CONSULTEE RESPONSE (Arun District Council - Arboriculturist)

Reference: LU/72/25/OUT

Proposal: Hybrid Planning Application comprising of the following: 1) - Outline application with all matters reserved (except access) for Phase 2 (West of Site) comprising development of approximately 8,800sqm GIA Light Industrial/Storage and Distribution (Use Class E(g)(iii) / B8), and 2) - Full Application for Phase 1 (East of the Site) for a food store (Use Class E(a)), 2 No. Drive-Thru food/beverage units (Sui Generis) with revised vehicular access, associated parking and landscaping. This application may affect the setting of a listed building and is in CIL Zone 2 and is CIL Liable.

Location: Land to the west of New Courtwick Lane, Wick, BN17 7RZ

DEMOLITION OF EXISTING OFFICE AND WAREHOUSE BUILDING

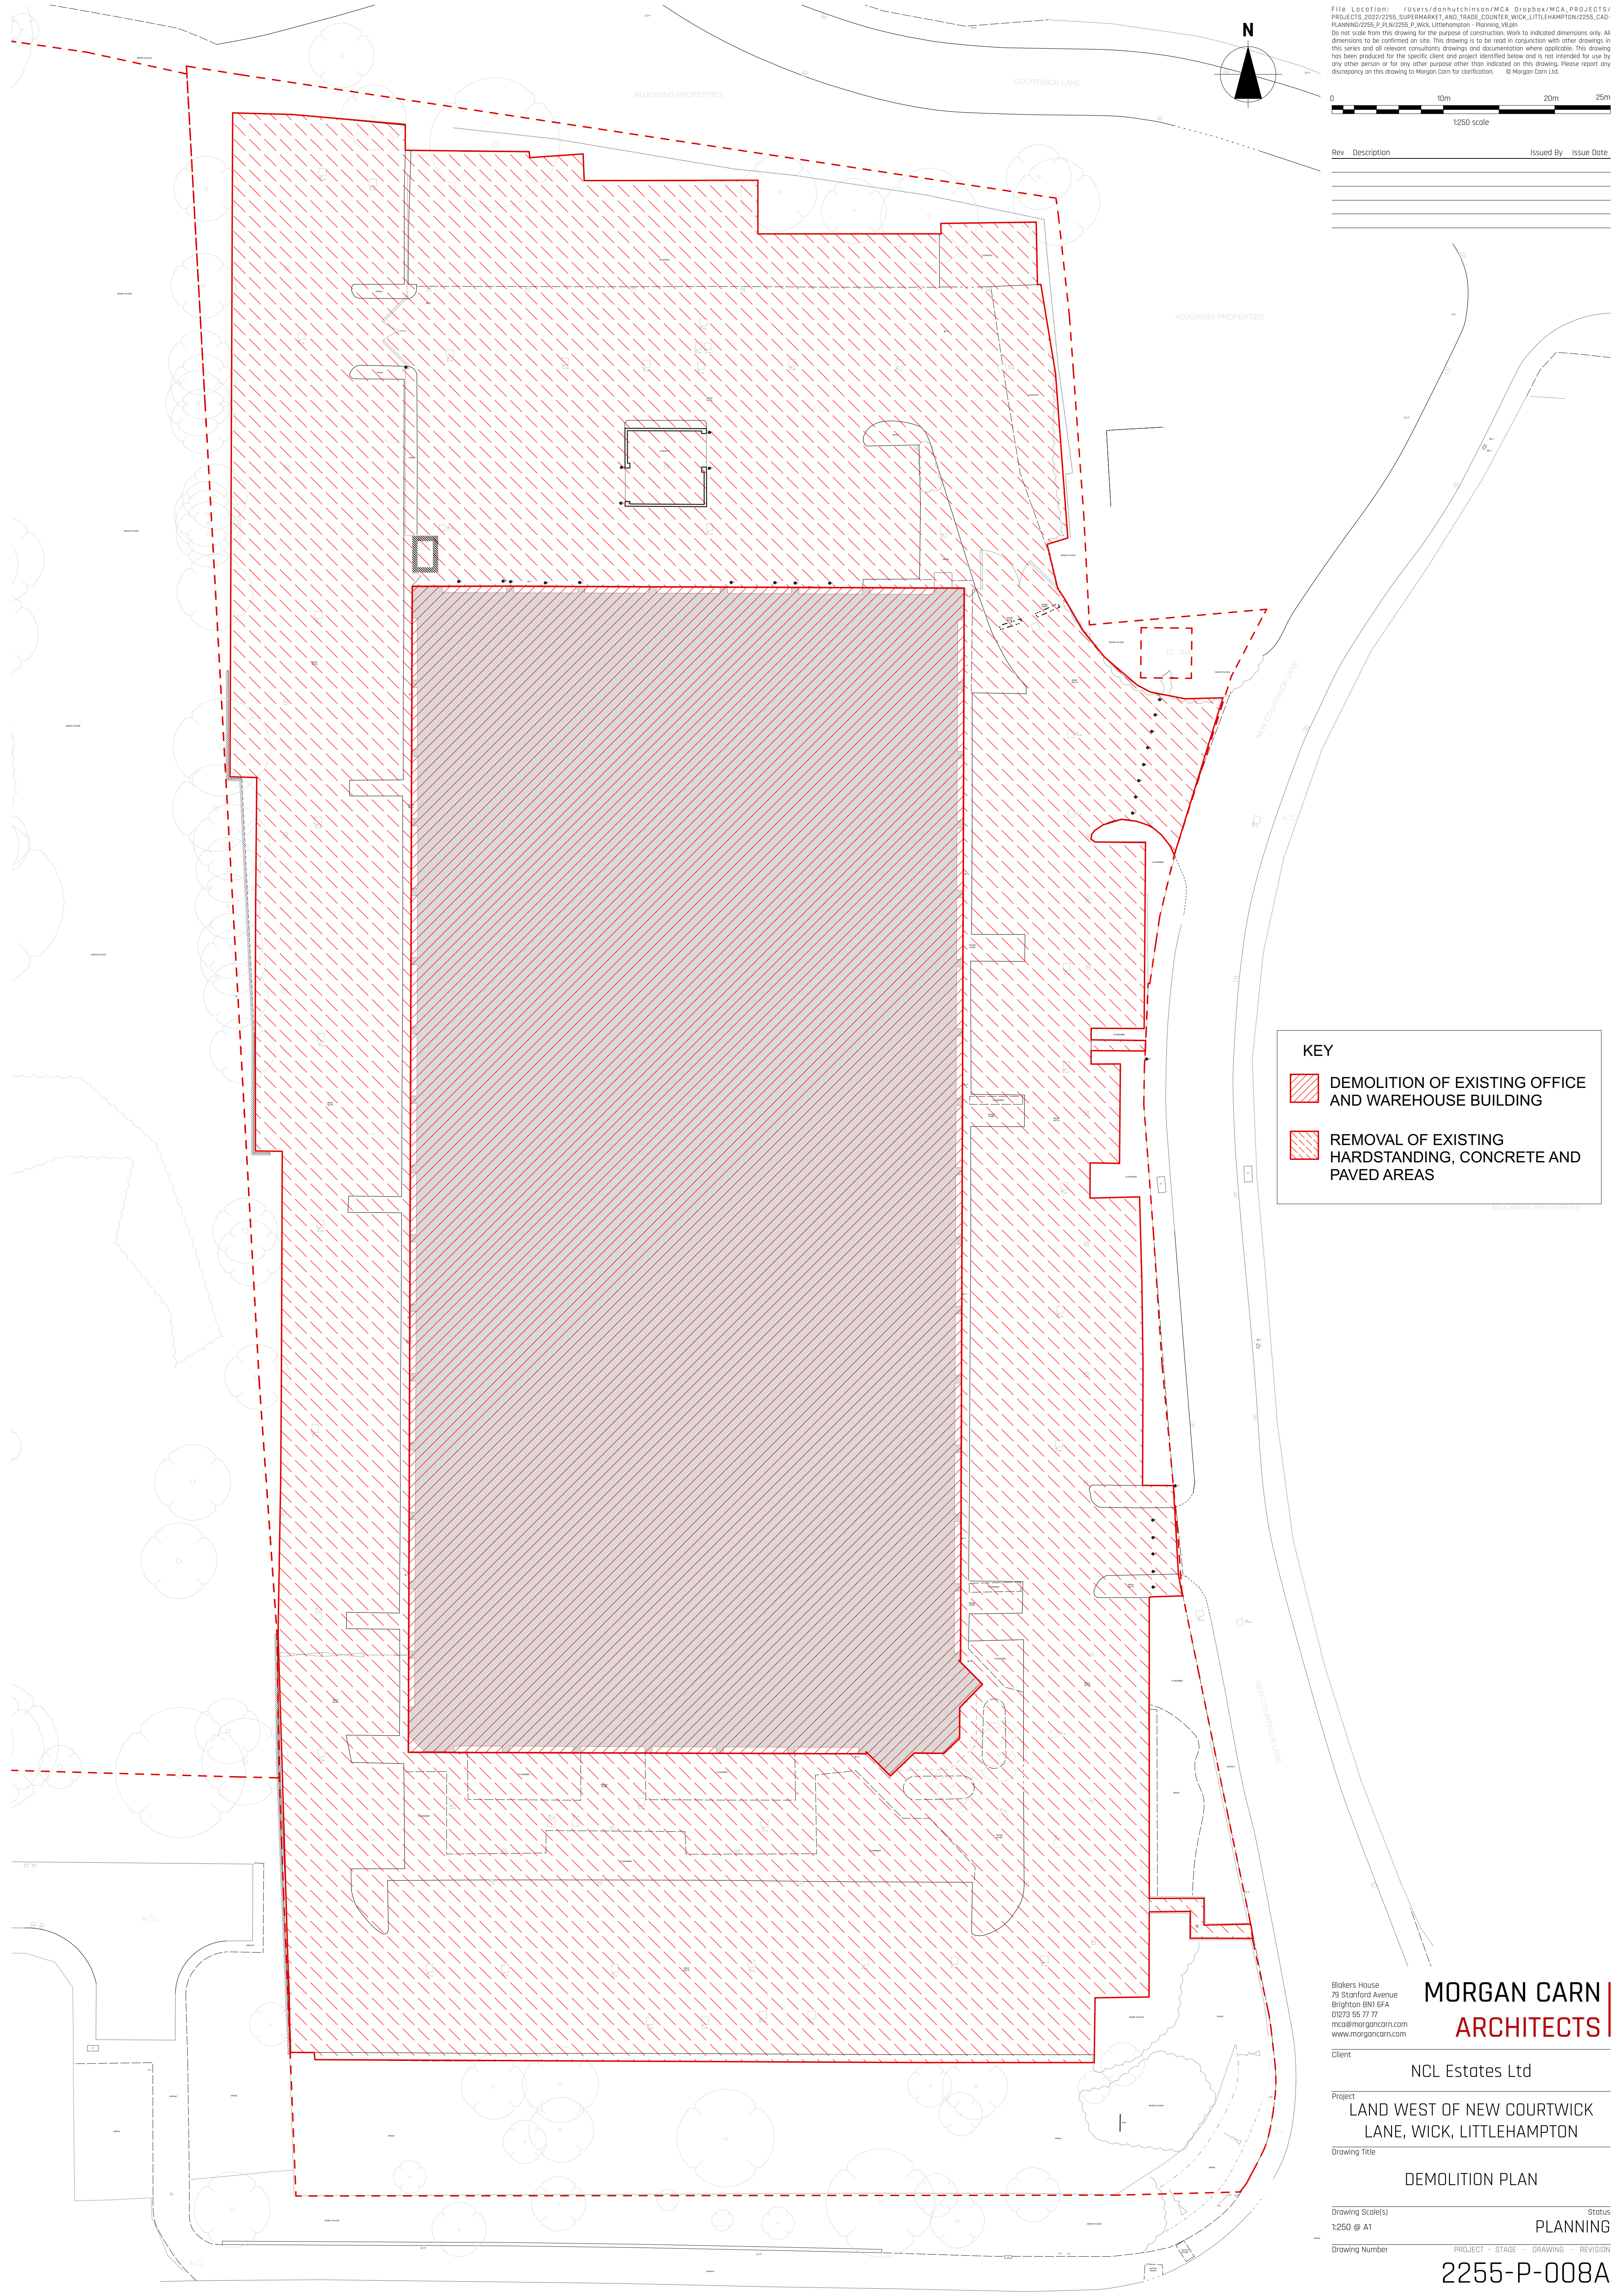
A principal concern is the need for close supervision by the project arboricultural consultant during sensitive demolition works (Demolition Plan, 2255-P-008A), undertaken within and adjoining the root protection area of retained trees. Parking bays and hardstanding at the northern end of site and large areas from the west boundary are of special interest. The AIA/MS sets out the working methods and programme of supervision for this work, which must be strictly adhered to if affected trees are to flourish post-development.

A finalised AIA/MS and Tree Protection Plan (TPP) will need to be submitted for our approval prior to commencement of any demolition or construction activity upon the site.
